Current Zoning: N1-A (Neighborhood 1)
Proposed Zoning: UR-2(CD) (Urban Residential, Conditional)

Approximately 19.75 acres located on the north side of Choate Circle between Legree Lane and Freshwell Road.

The petition proposes to allow redevelopment of a site in the Steele Creek community with a multifamily residential community containing 350 dwelling units and accessory uses.

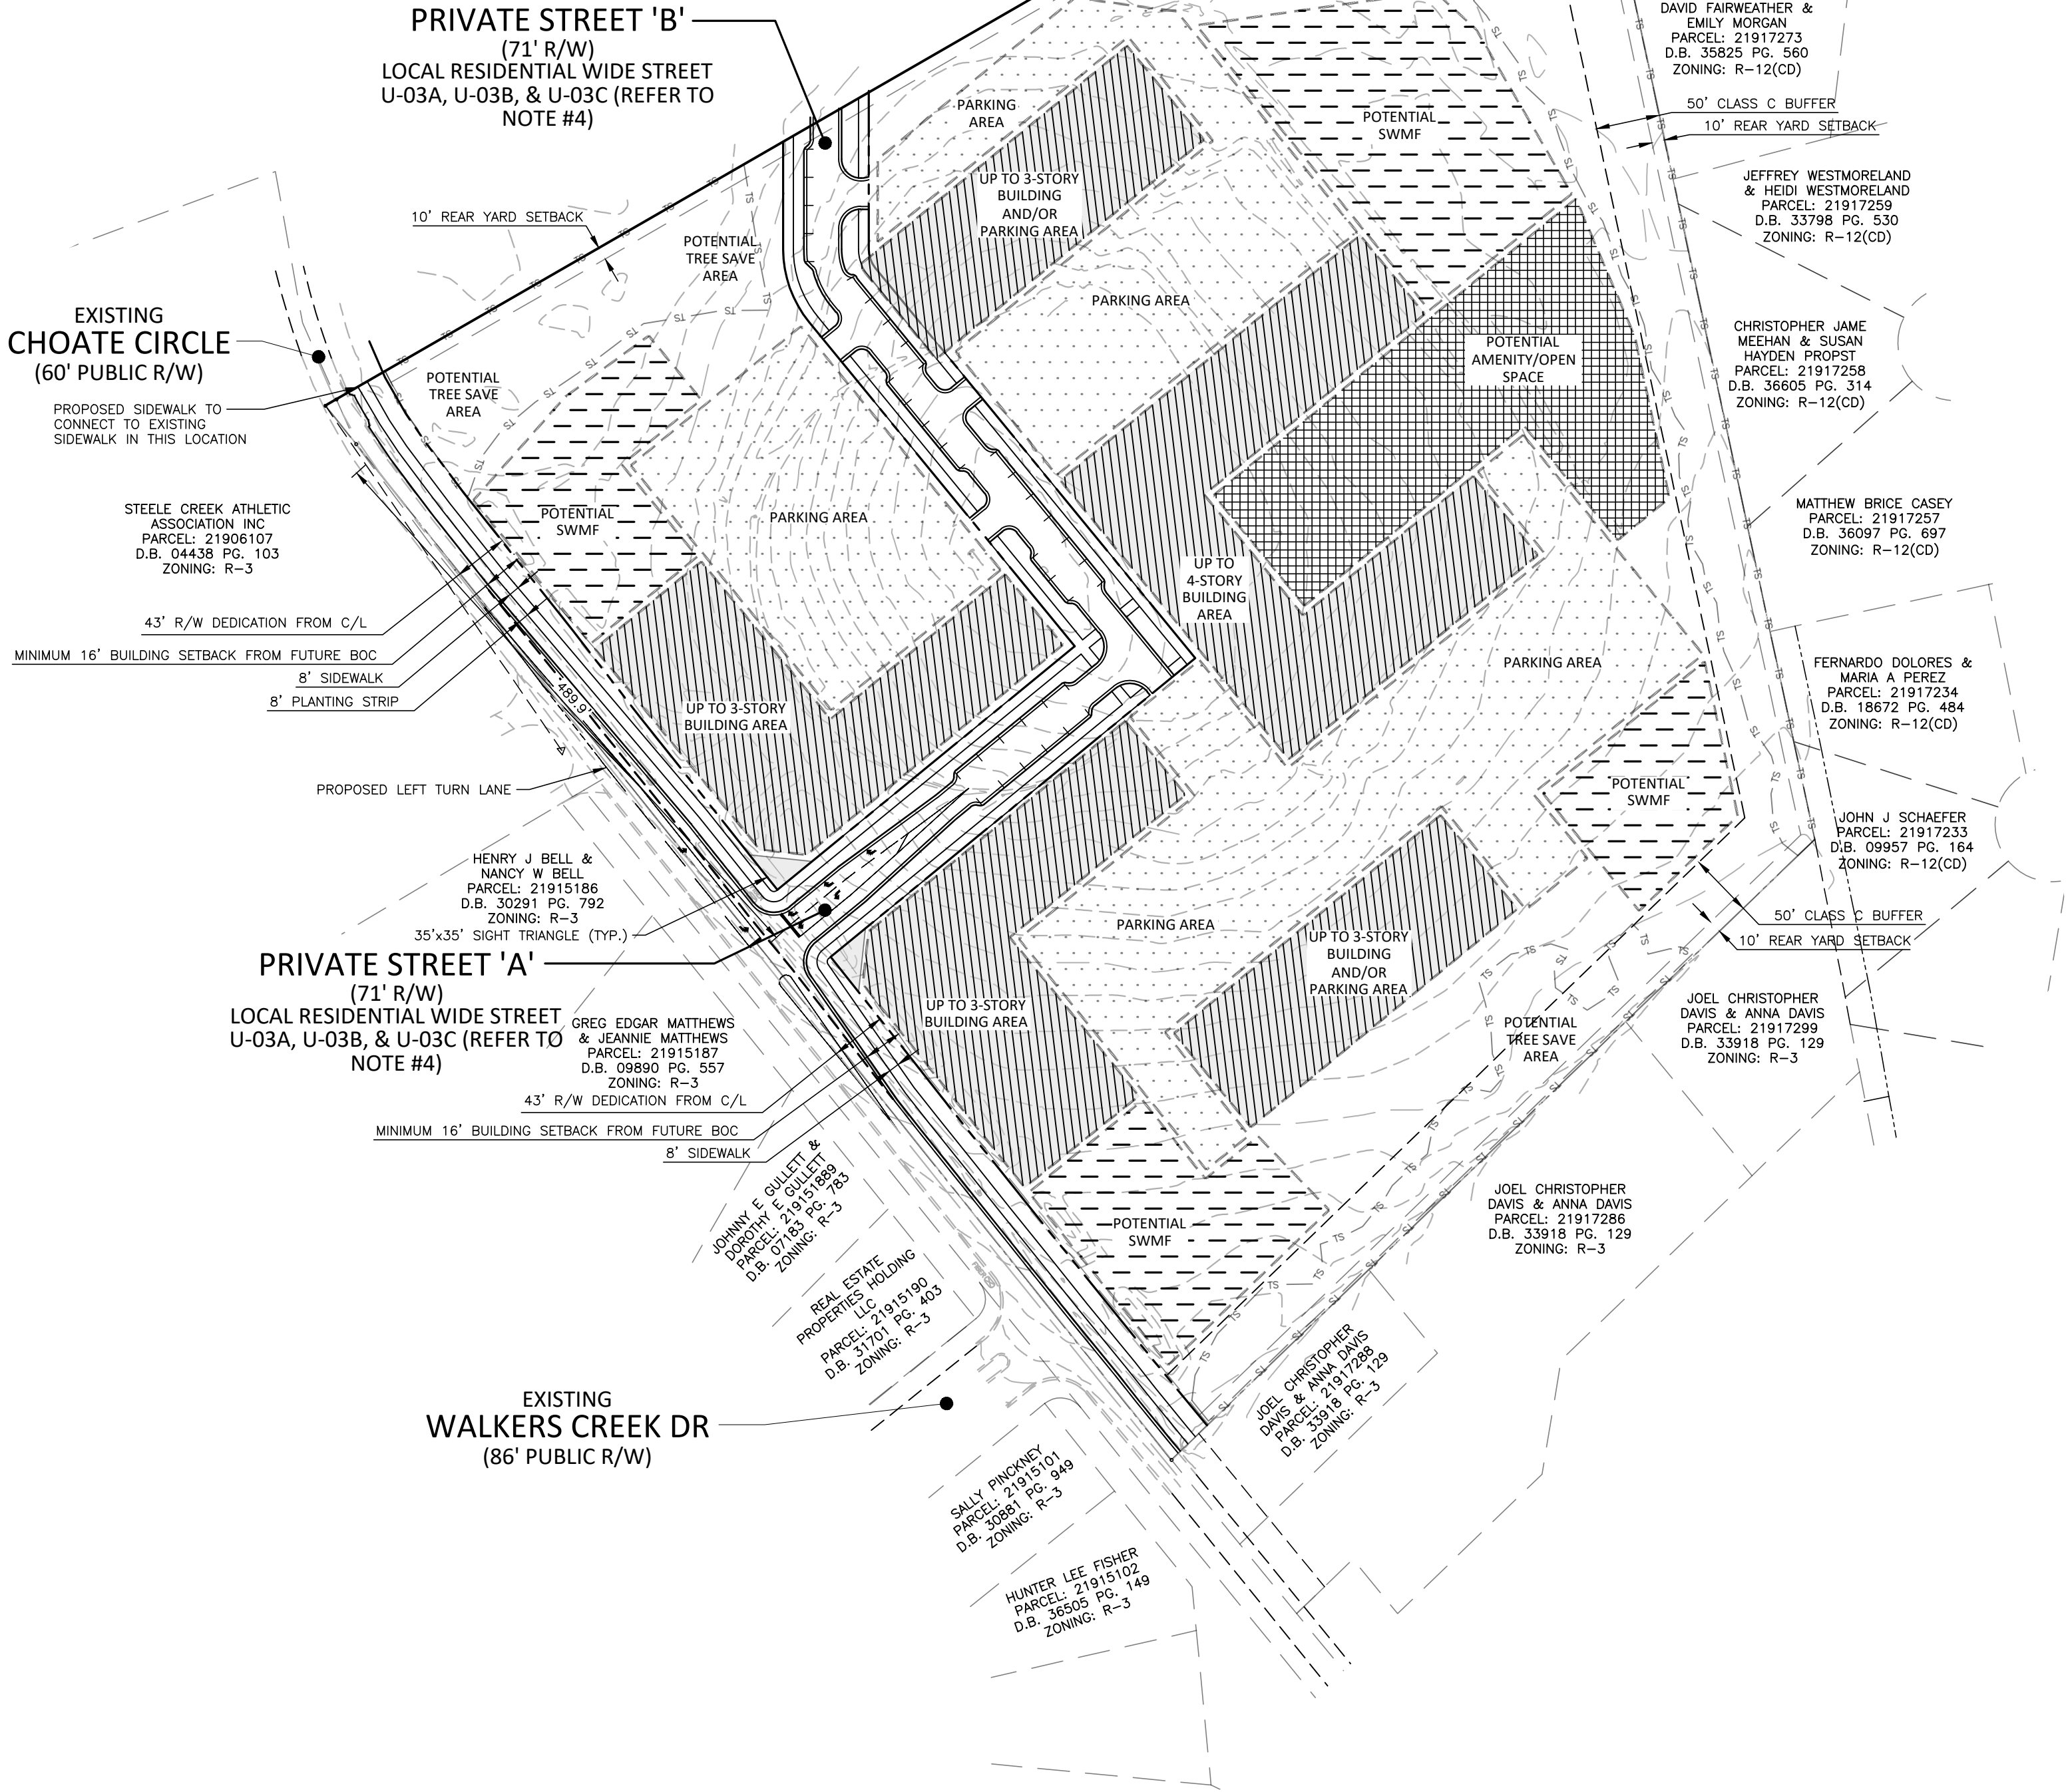
1. ~~Revise the site plan and conditional notes to convert the proposed private streets to public streets.~~

ADDRESSED

3. ~~Delete the word "building" from setback note on site plan.~~ ADDRESSED

4. ~~Delete the second sentence of note 4.c stating "The proposed Class C buffers may be made of existing vegetation and new vegetation".~~ ADDRESSED
